Your ref: SSD 6799 MOD 1
Our ref: MC-14-2312

Modification to the Cold Storage Facility at Hollinsworth Road, Marsden Park

Issues for consideration – SSD 6799 MOD 1 for the 'Swire Cold Storage Facility'

PROPOSED SITE PLAN

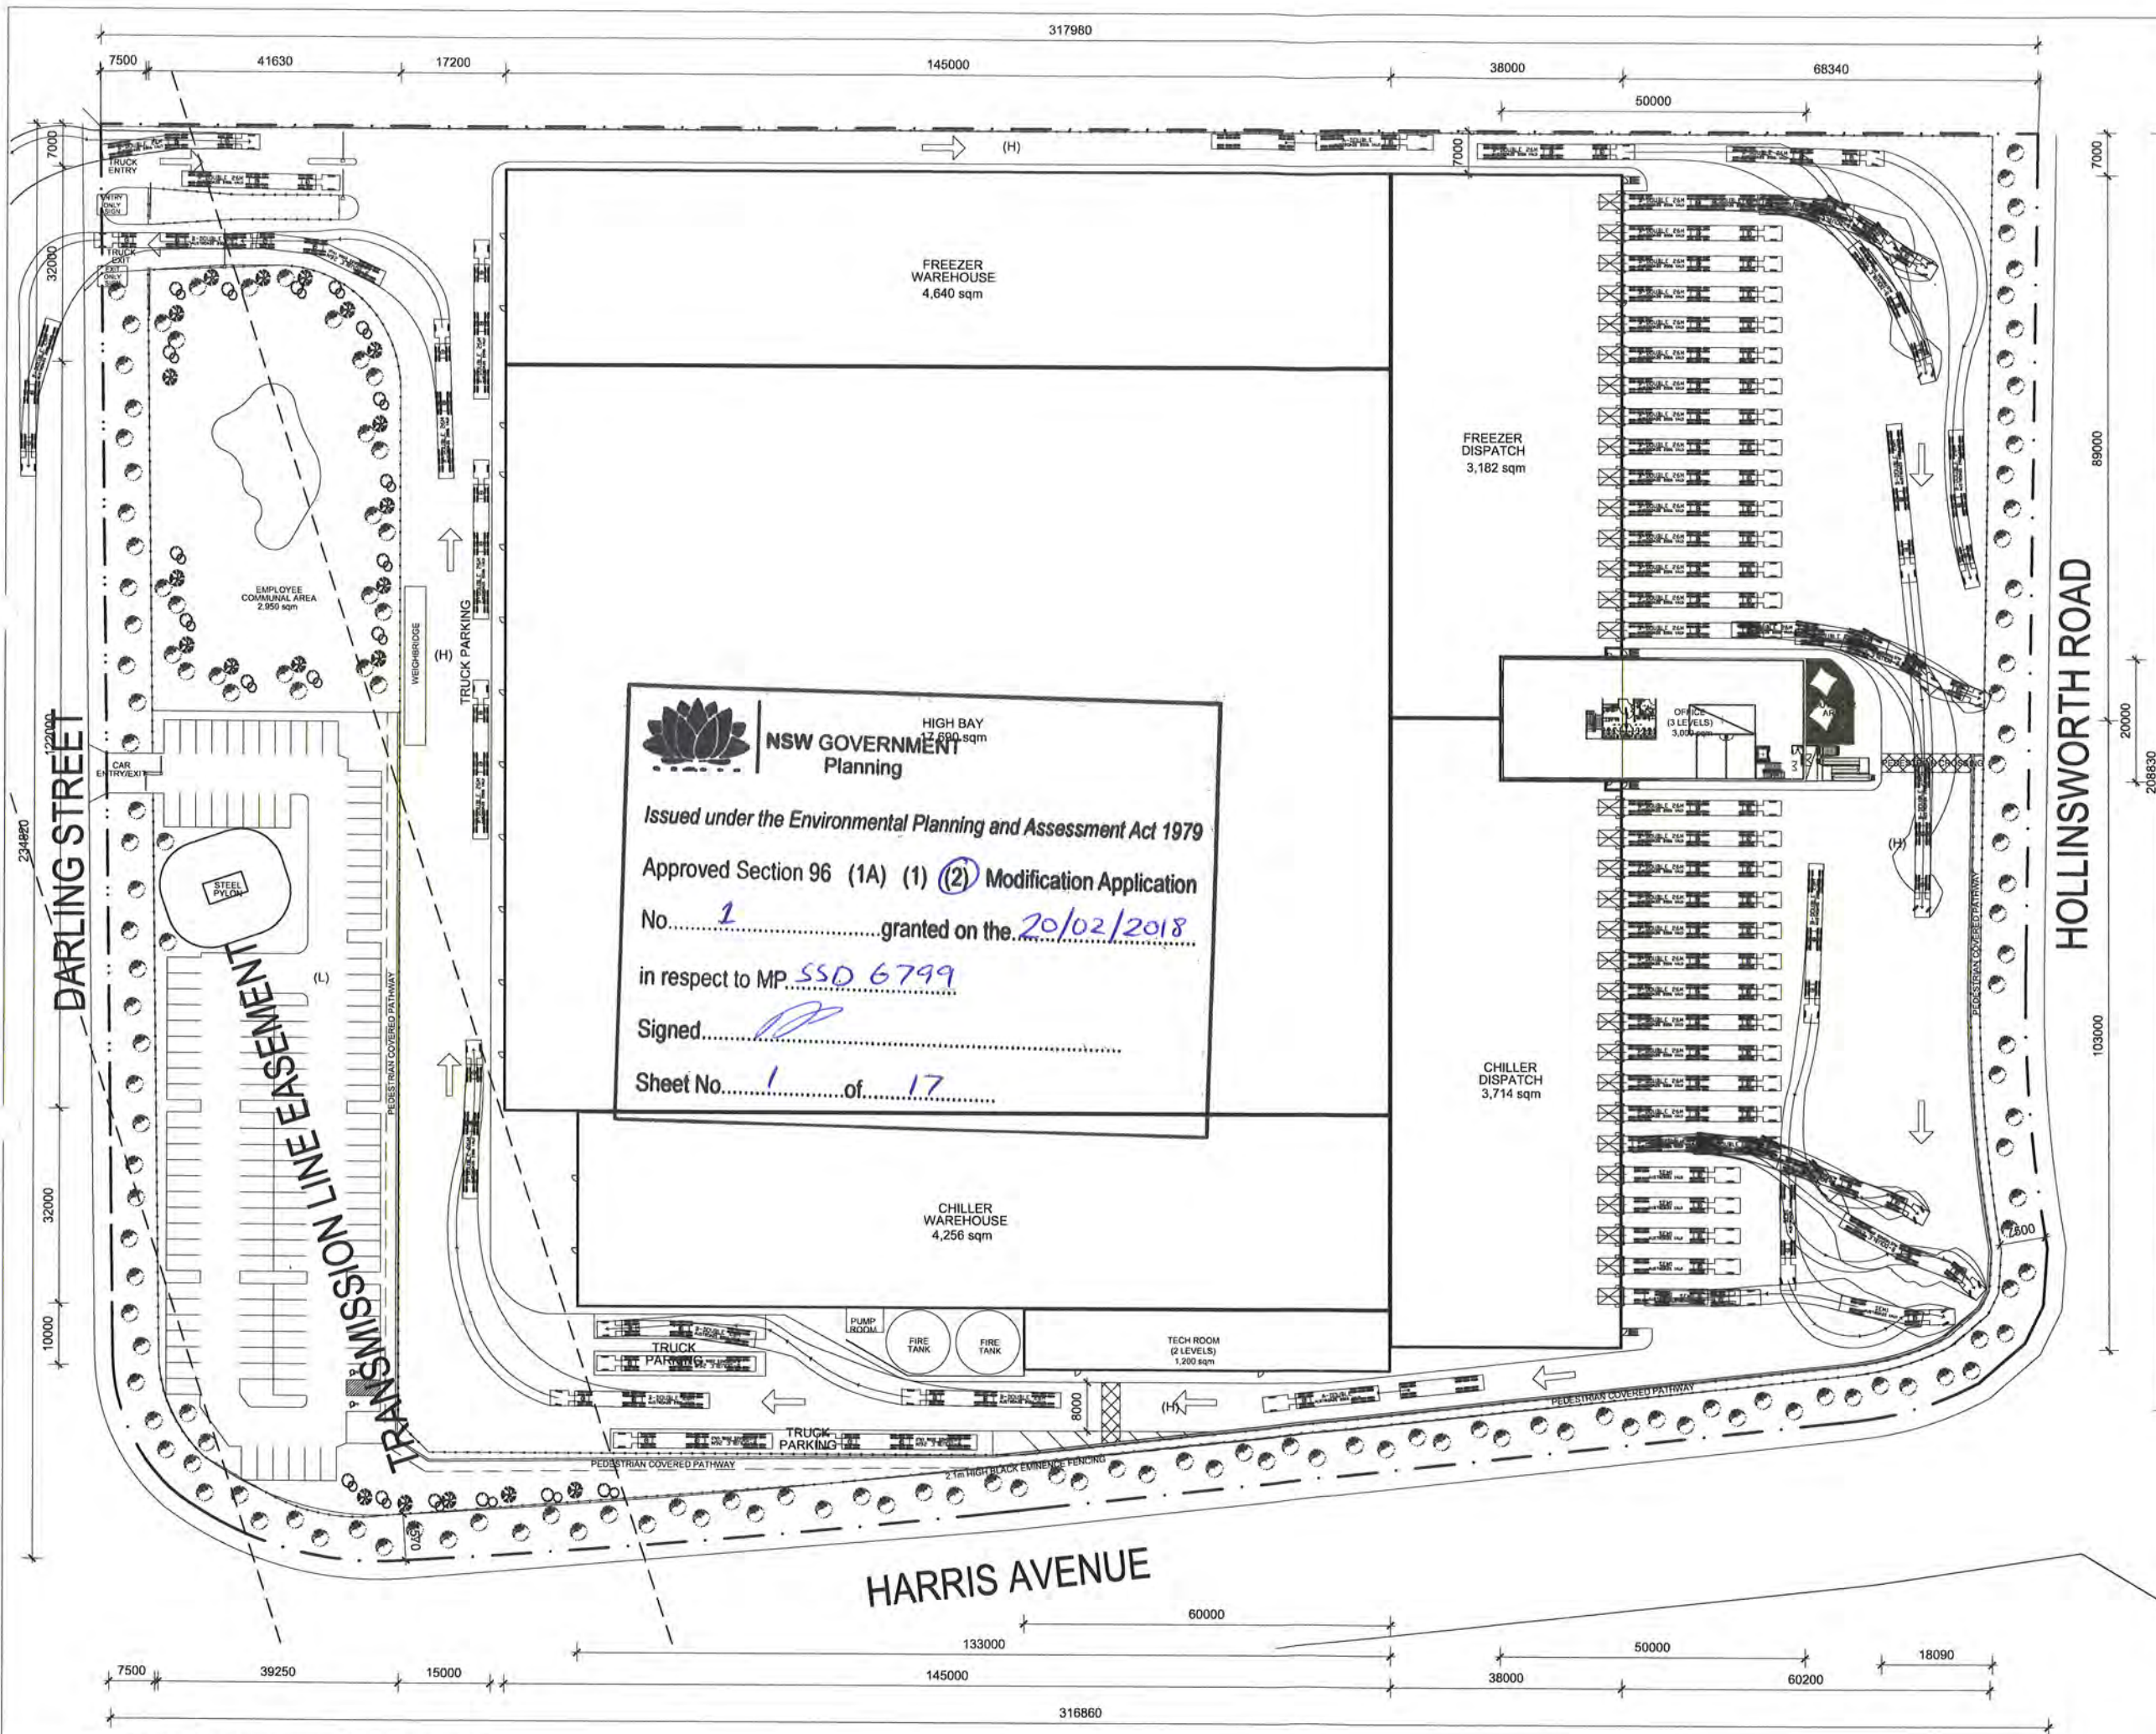
- a. We are concerned that the truck dispatch area, adjacent to the Hollinsworth Road frontage, could be used for external storage purposes when not being access by trucks. We do not support any external storage of goods within any of the setback areas, especially to Hollinsworth Road. All storage must be within the building or behind a suitably screened area. This issue should be addressed by way of a suitable condition.
- b. The plans nominate that the fire tanks will be screened. Conditions should be included requiring that the applicant submit details of any screening for separate approval.

- a. The site layout results in travel (walking) distances of over 300 m from the car park, including the accessible parking spaces, to the building entry and offices. The car parking spaces are therefore considered inappropriately located. Furthermore, no details have been provided of the proposed covered pathway. The car parking area, including the accessible spaces, should be relocated adjacent to the building entry.
- b. The proposed development requires a minimum of 311 car parking spaces. The approved development consent, however, only requires that 128 spaces be provided. This is a significant variation from the minimum parking requirement under the DCP. We object to a further reduction in the number of car parking spaces on site for the following reasons:

- c. We consider that an area should be set aside for additional car parking to be provided in the future, so that parking provisions can comply with the minimum requirements of the DCP if the demand arises. At the very minimum, no further reductions should be given to the approved 128 car parking spaces. Any further departure from the minimum DCP parking requirement may have negative impacts on the surrounding developments in the future, and should not be supported.

DRAWING TITLE
PROPOSED ELEVATIONS

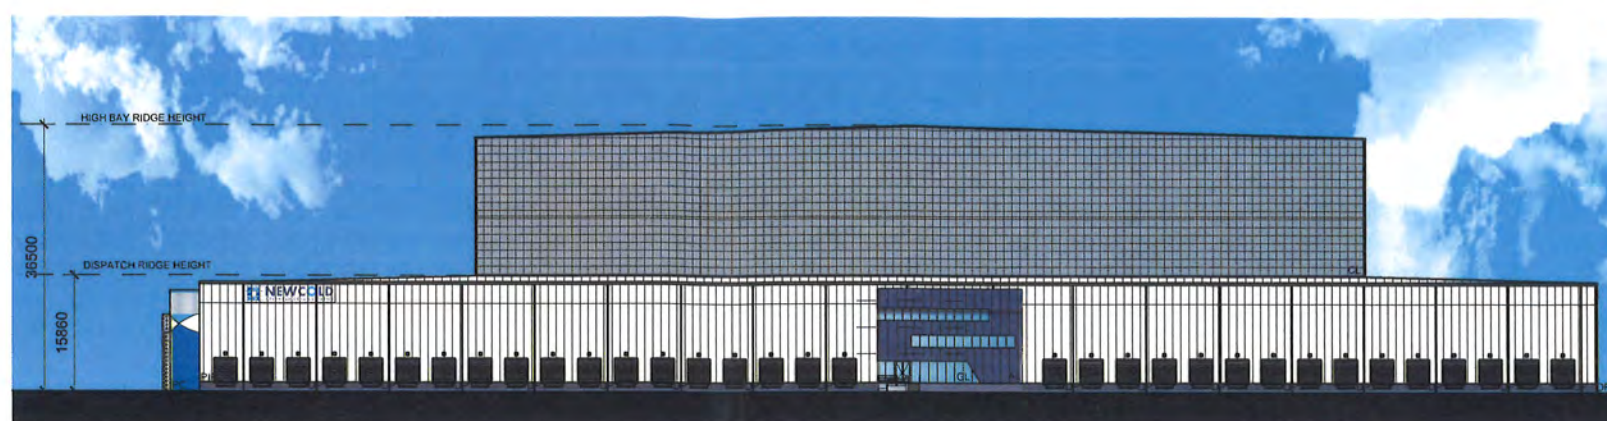
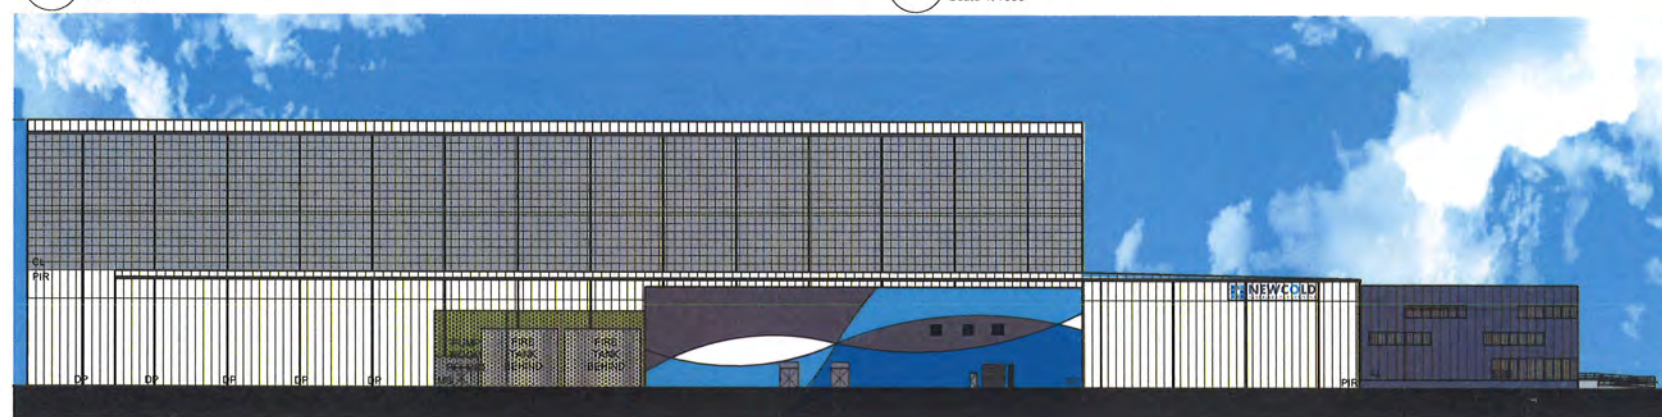
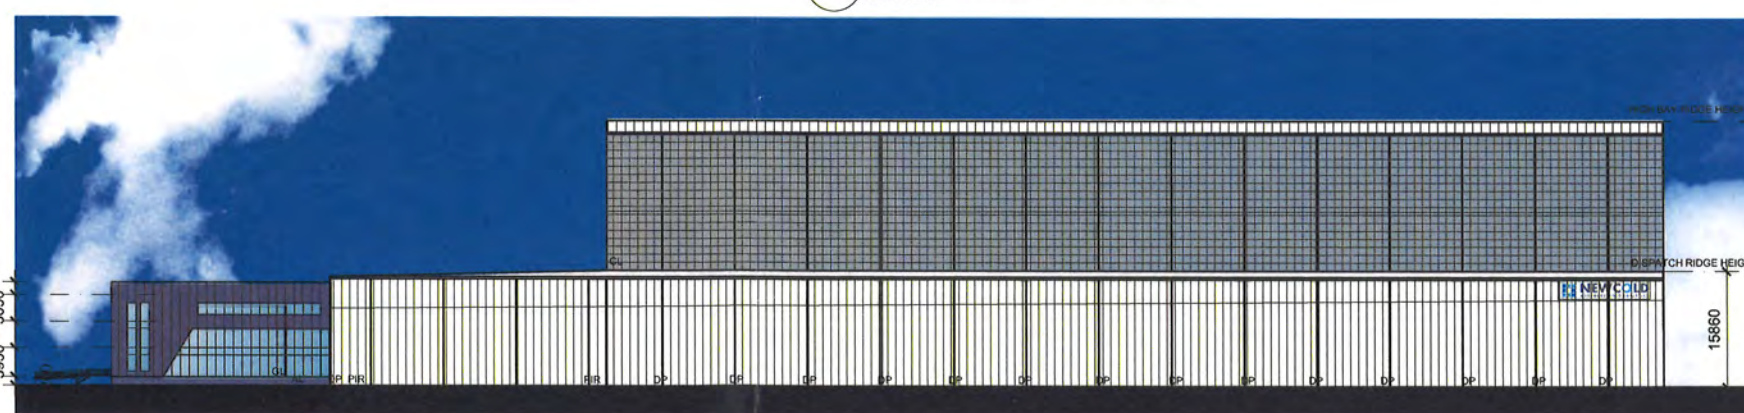
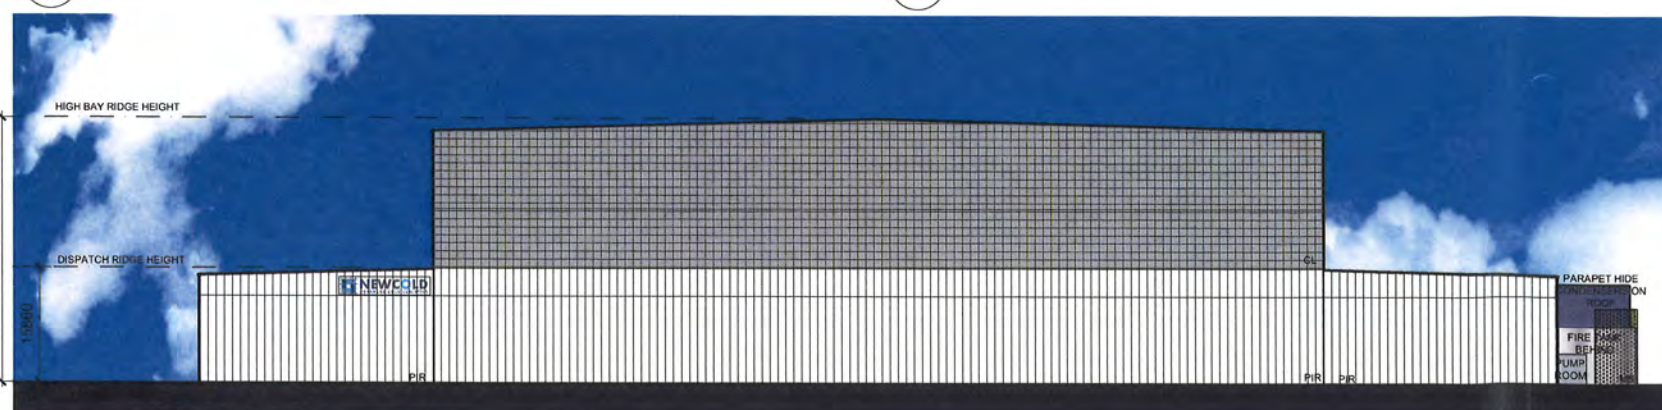
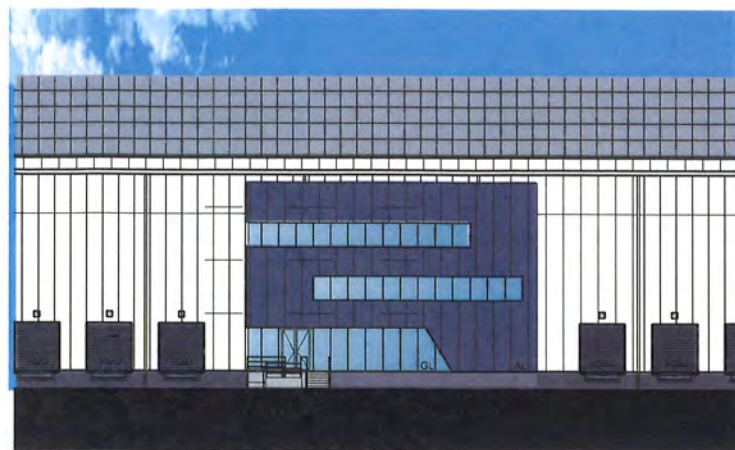
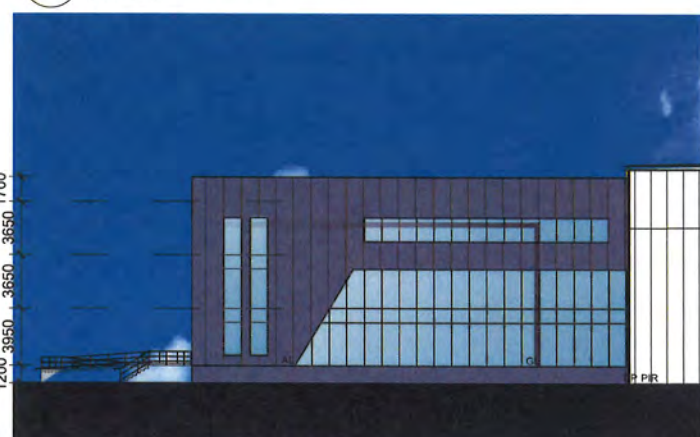
- b. The following concerns have been raised by our City Architect:
 - i. The building significantly exceeds the 16 m height limit that applies to the site. The external appearance and form of the building therefore requires careful detailing. Appropriate material selection is also required to ensure that the development contributes positively to its surrounding context and does not have an adverse impact on the intended scale and character of the area.

- iii. The 3 design options presented for consideration are fundamentally the same, albeit with minor colour and pattern variances. The form is defined by functional and operational parameters rather than aesthetic or design considerations. All 3 options present as an over scaled development consisting of a singular material with no relief to the building facade through either material variance or articulation.

- iv. The building façade does not provide any architectural merit and does not demonstrate design excellence. A building of this nature, that has a significant breach in the height limit, has the opportunity to provide design excellence and improved character of the precinct. The proposal in its current form does not contribute positively to its context.

- v. The office component of the development does not provide any additional visual interest on site. The office comprises standard curtain walling and metal cladding with no attempt made to exhibit any element of aesthetic interest.

- d. Based on the above, we strongly object to the proposed building height and visual presentation of the development. It is considered that the development does not promote a high quality built form in accordance with objectives (b) and (d) of the Height of Building standard under Clause 4.3 of the Marsden Park Industrial Precinct Plan – Appendix 5 of the Sydney Growth Centres SEPP, and the proposed 36 m high building provides a lack of architectural merit.

condition requiring that prior to the issue of any Construction Certificate, amended plans providing architectural features which break down the bulk and scale of the building and which ameliorates the visual presentation of the overall structure, be submitted to the satisfaction of the Blacktown City Architect. The amended facades must also be complemented with appropriate landscaping to the satisfaction of Blacktown Council's landscape architect.
